Norfolk Vanguard Offshore Wind Farm

Change 2

Response to Points of Clarification Letter

Developer: Norfolk Vanguard Limited and Norfolk Vanguard East Limited
Document Reference: PB5640.008.0087

Drawing file: published-documents / EN010079-001653-Figure 4.07 Landfall Location.pdf

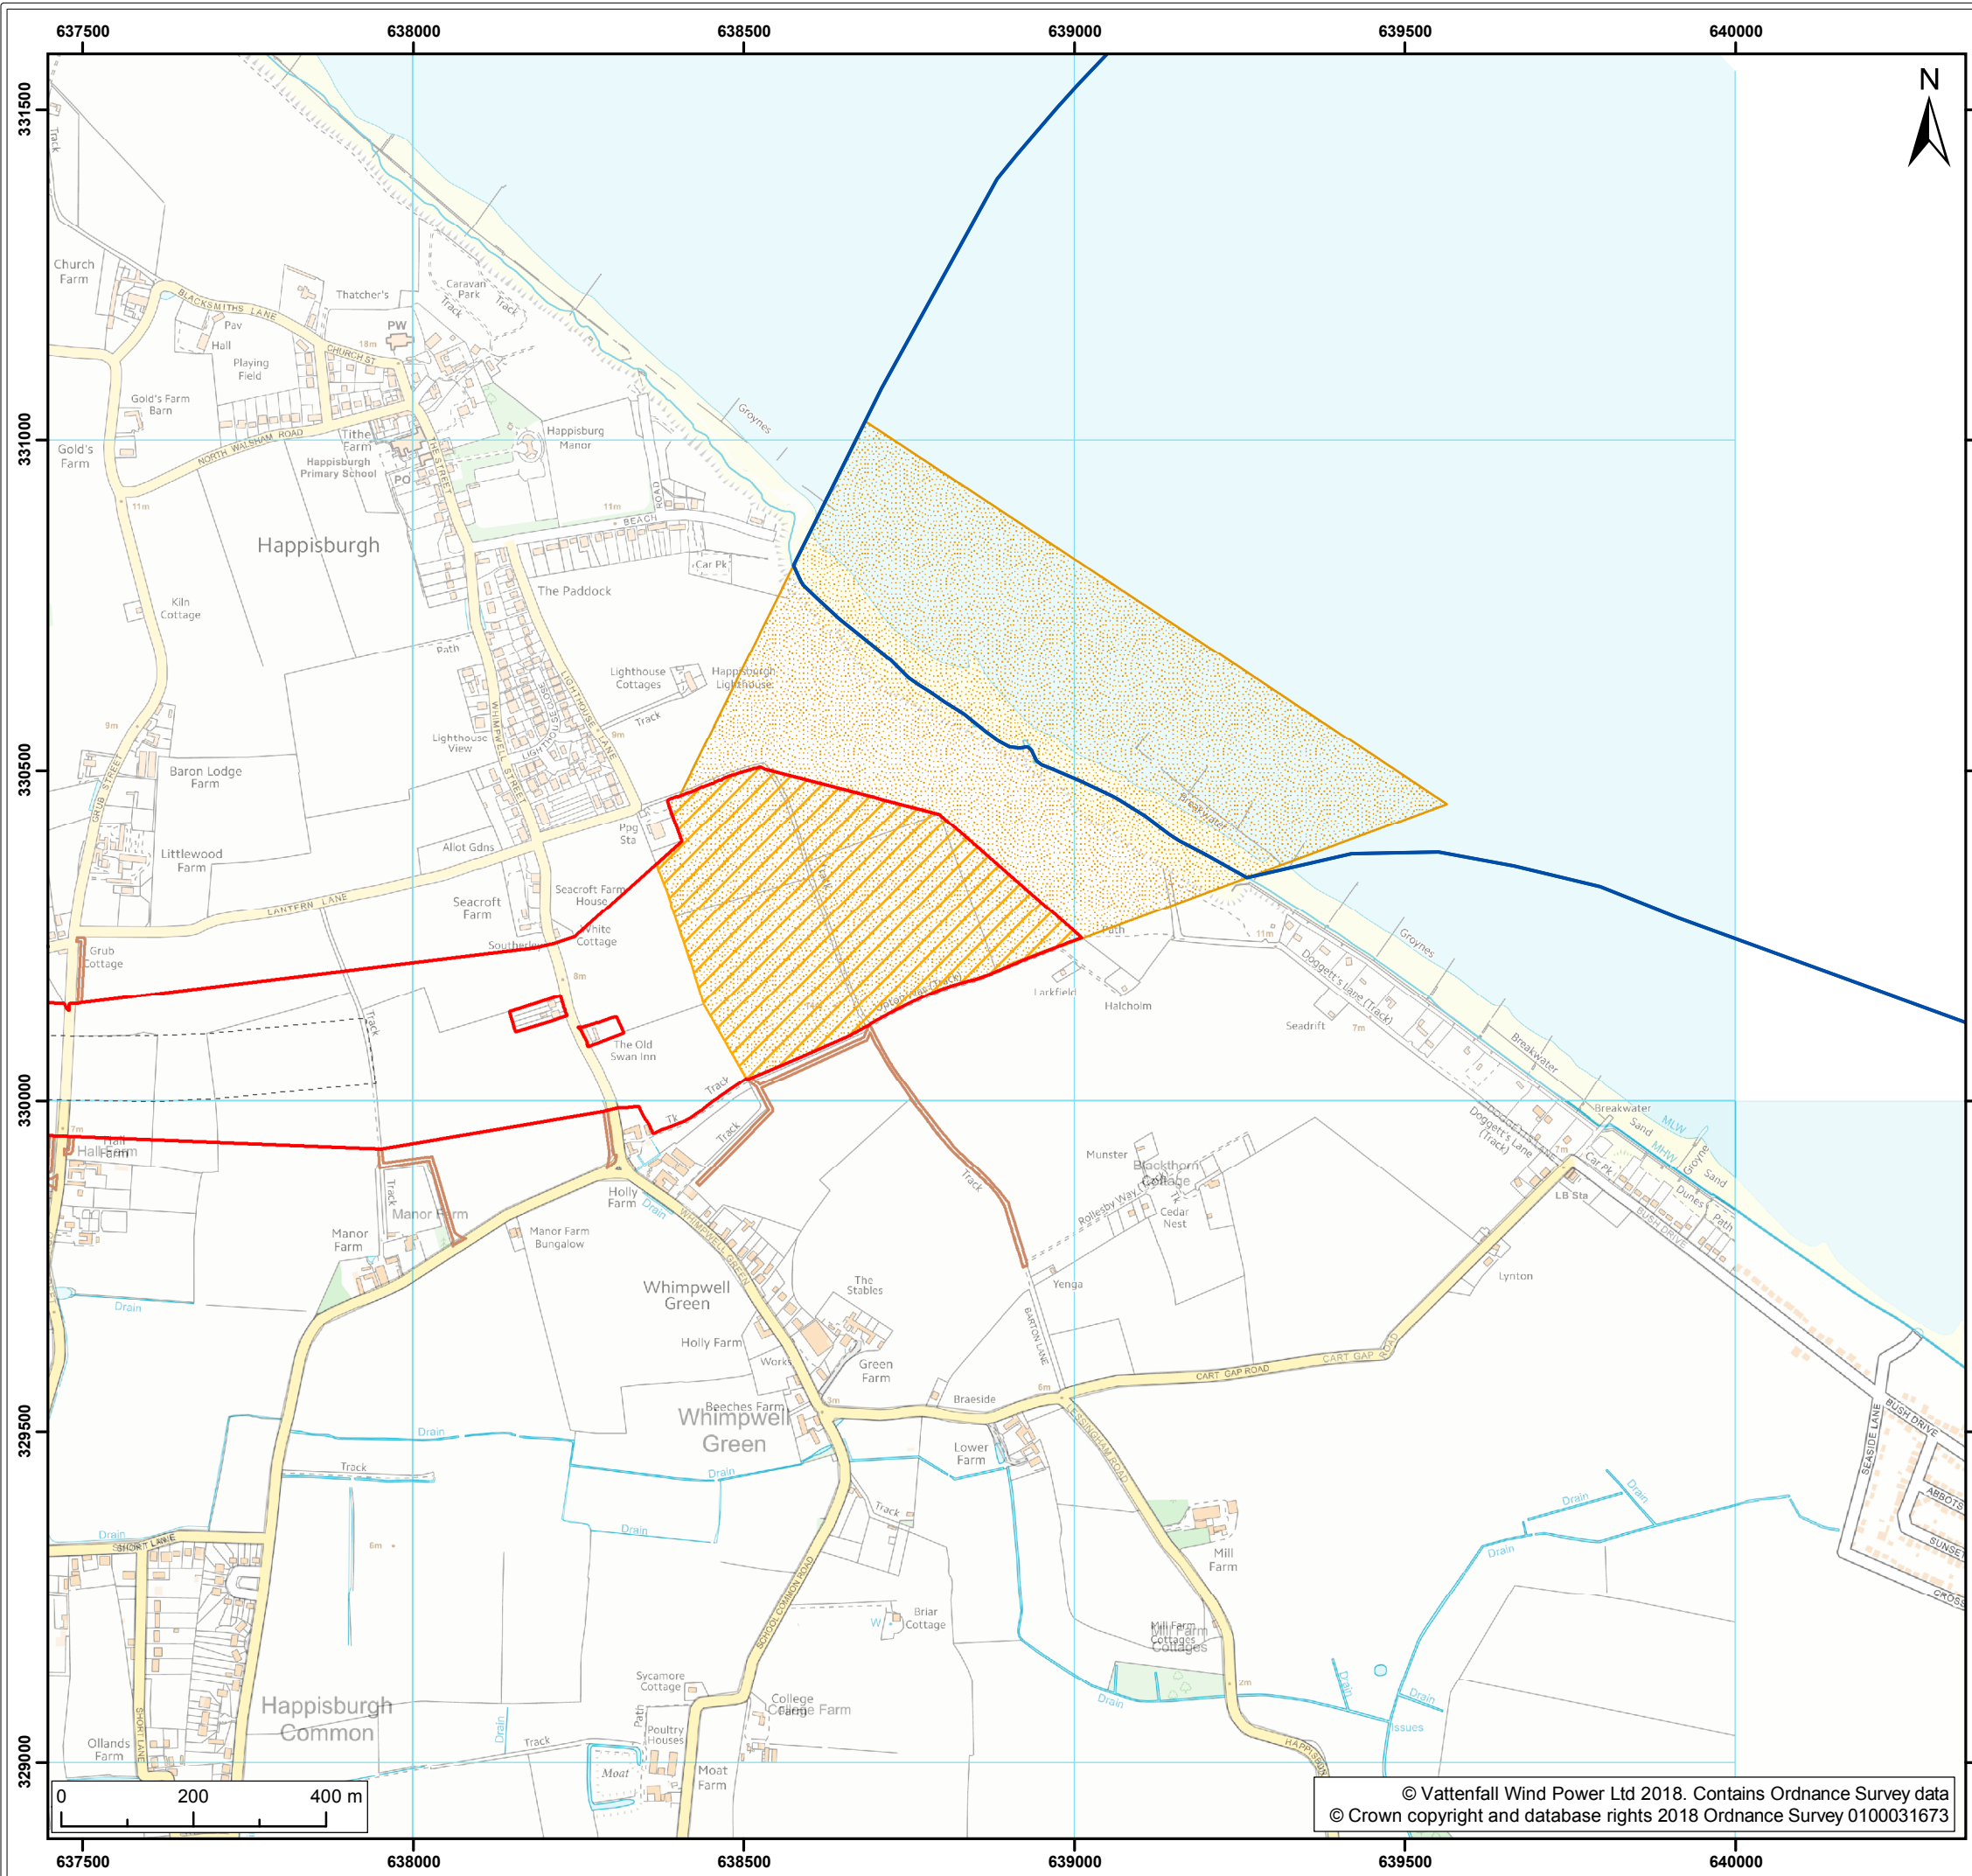
The Secretary of State notes that Figure 2 of the 2023 Application (Supporting Statement) appears to show physical cross-over between the landfall compounds of Vanguard with those of Boreas, which are shown in Figure 4.7 of the Boreas ES². The Applicant should provide a plan showing the layout at landfall which combines all details for both Vanguard and Boreas.

14. The Applicants' response is as follows:
15. It is important to note that Figure 4.7 of the Norfolk Boreas ES shows "indicative" landfall compound locations and that the DCOs allow for these to be located anywhere within the Landfall compound zone. The same applies to Figure 2 of the NMC2 application. Some further detailed design work has occurred in order to progress the NMC2 application; however, the exact locations of the landfall compounds will only be confirmed at the point at which the Landfall Method Statements (secured through Requirement 17 of the Norfolk Vanguard and Norfolk Boreas DCOs) are approved.

16. The Applicant has provided a plan below showing an indicative layout at landfall which combines landfall infrastructure under the Norfolk Vanguard and Norfolk Boreas DCOs. This was not included within the NMC2 Supporting Statement as the application is only to change the Norfolk Vanguard DCO and it was considered that it may cause confusion to include Norfolk Boreas infrastructure given that there is no equivalent NMC application to change the Norfolk Boreas DCO.
